Consultation Response from KC, Lead Local Flood Authority
2021/93270 Land at, Station Road, Skelmanthorpe, Huddersfield, HD8 9BA
Discharge of conditions 3 (construction management), 4 (temporary drainage), 5 (temporary waste arrangements), 7 (adoptable roads), 12 (waste storage and collection), 13 (tree protection), 14 (units 23 and 24 revisions), 16 (detailed drainage scheme), 17 (phase II report), 18 (remediation strategy), 23 (materials) and 31 (vegetation removal) of previous permission 2019/91657 for erection of 30 dwellings
Date Responded: 11th January 2023 Responding Officer: Paul Farndale Responding Ref:

Condition 4 – Temporary Drainage

PHASE 2 - SCALE 1:500

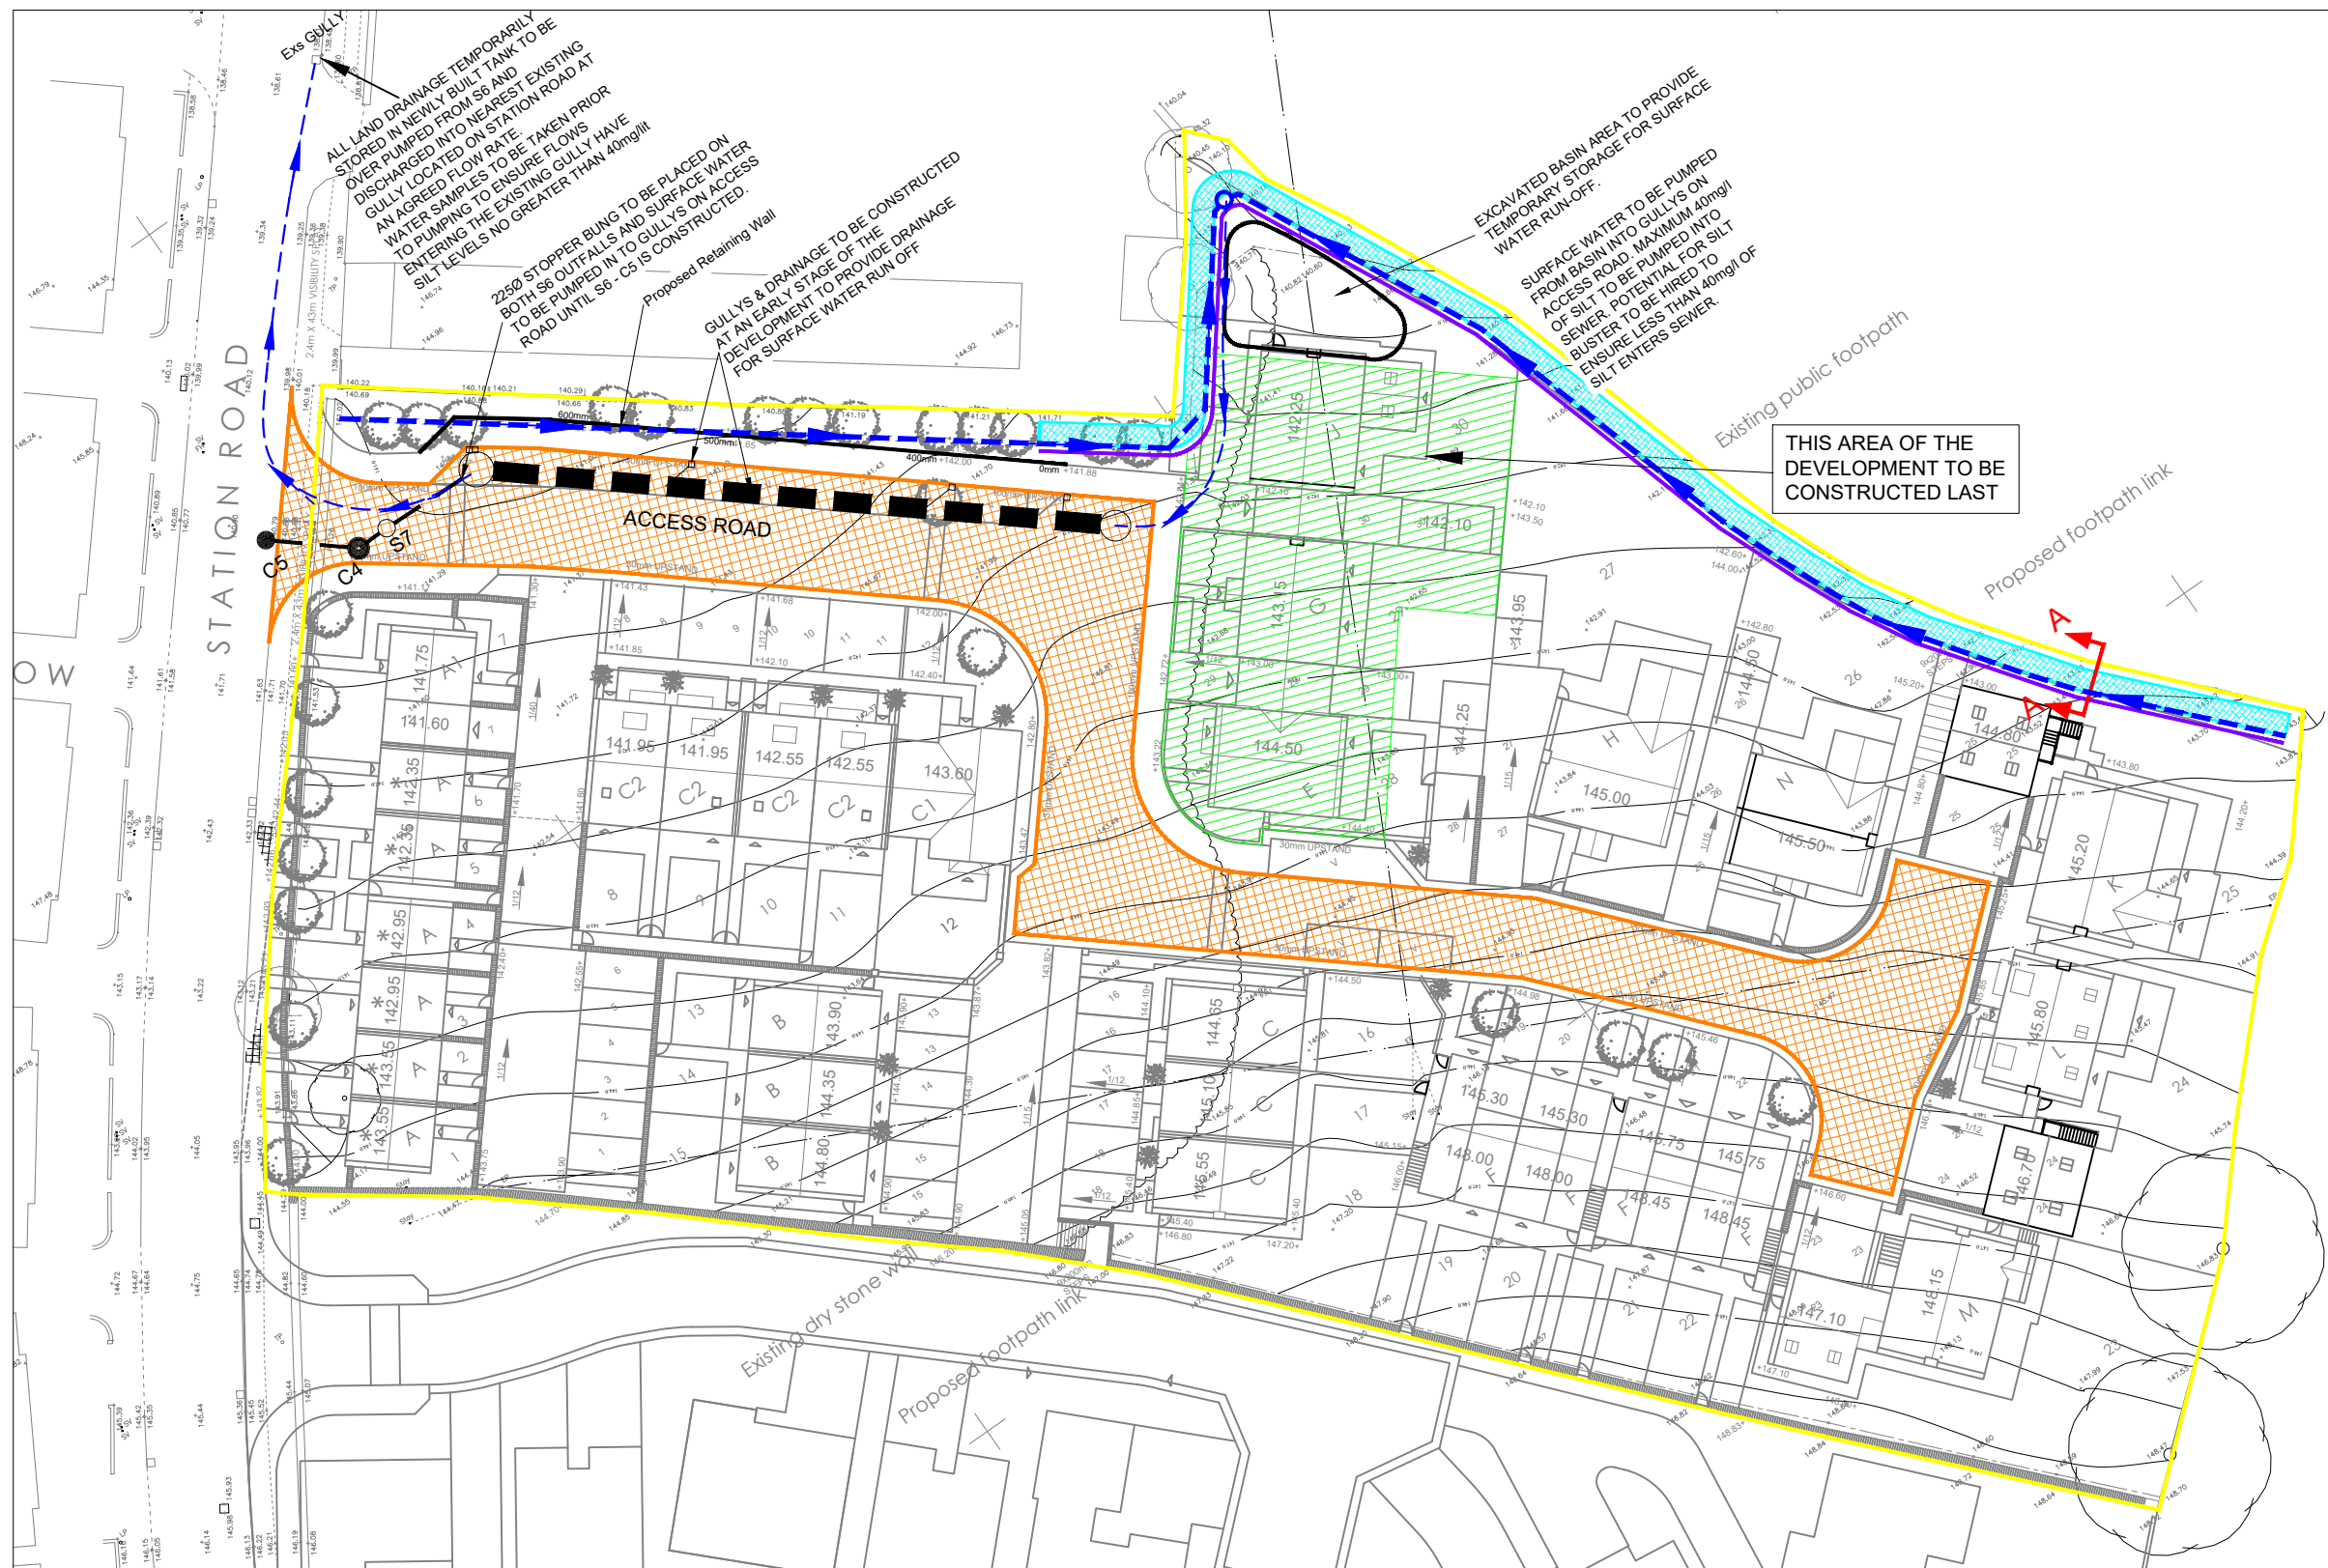
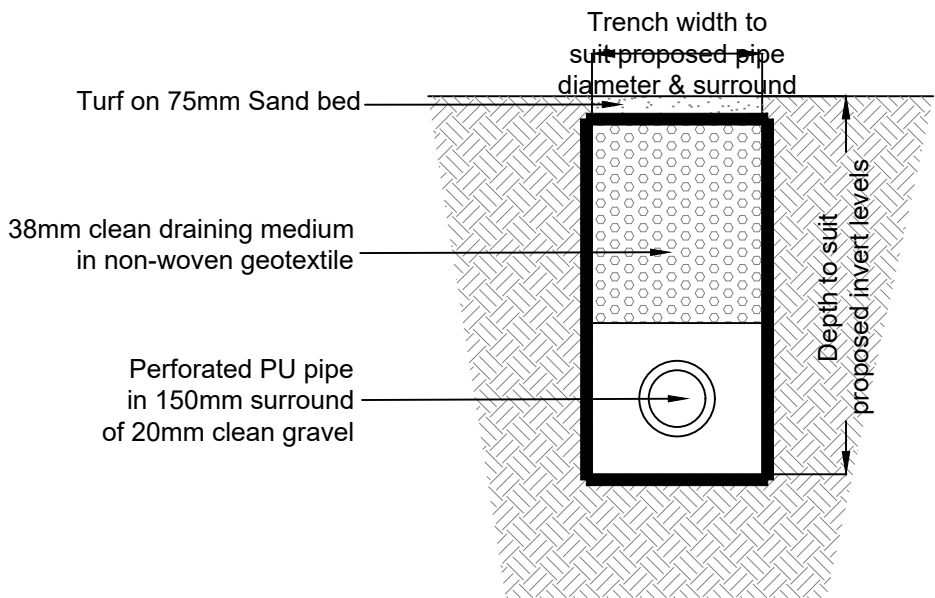
We note and accept the revised construction phase drainage plan utilising the storage tank as a settlement tank prior to over pumping to systems connected to the watercourse, Baildon Dike.

We do advise the developer liaises with the Environment Agency as to whether the methods concerned are labelled as 'treatment' and whether waste licences are required.

Should sediment in surface water leaving the site be a problem we suggest monitoring of samples and the use of flocculation to be considered if necessary.

We are also aware that re-emergence of surface water in neighbouring land is occurring, and several locations have been dye-tested to prove a link from particular areas of the site. The LLFA will continue to work with the developer on this live site to minimise flood and pollution risk.

The accepted plan will need to be monitored and revised where necessary.
